Response to Modification to Tweed Valley Hospital Concept Stage 1

I am therefore writing **to object to the proposed Modification to Tweed Valley Hospital – Stage 1** as outlined in the following points:

SOUTH ELEVATIONS

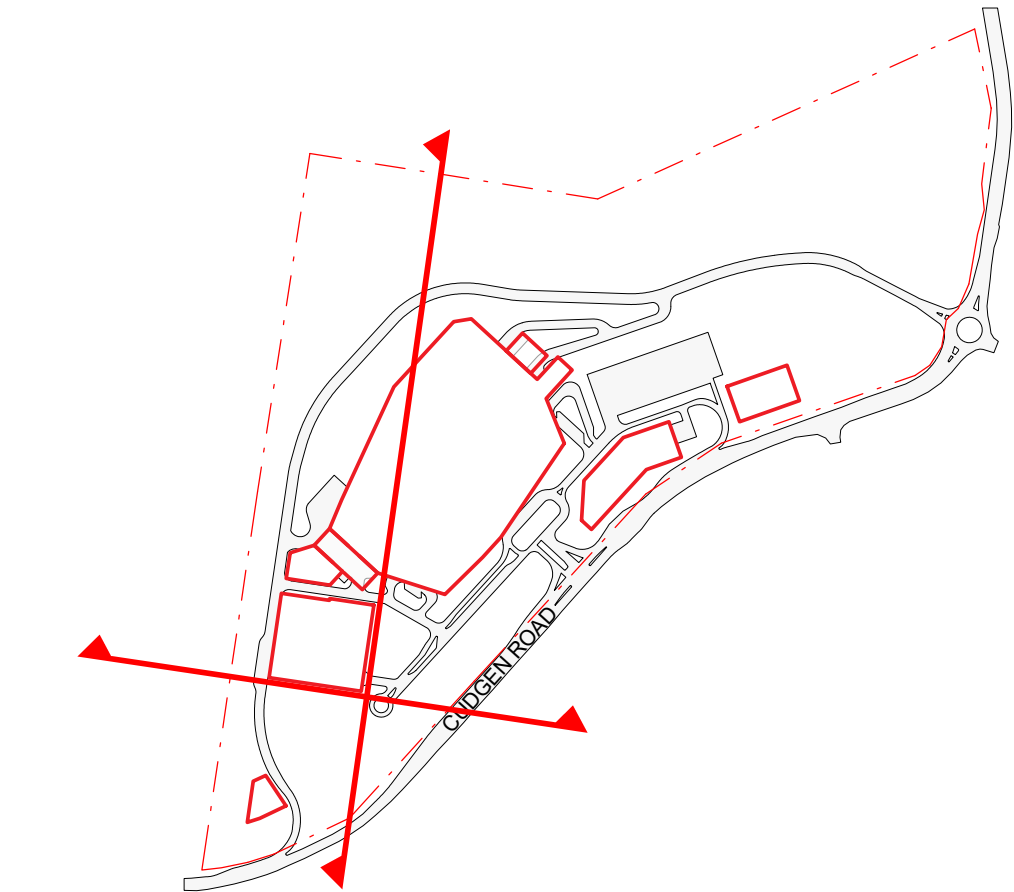
I also argue the below architect's portrayal of the ten storey carpark is misleading, if the TVH is to be only nine storey's, how can the ten storey carpark be so much lower. You can see in my first photo that there is not a significant difference between the earthworks for the TVH and the nearly completed earthworks for the proposed (but not yet approved), ten storey carpark.
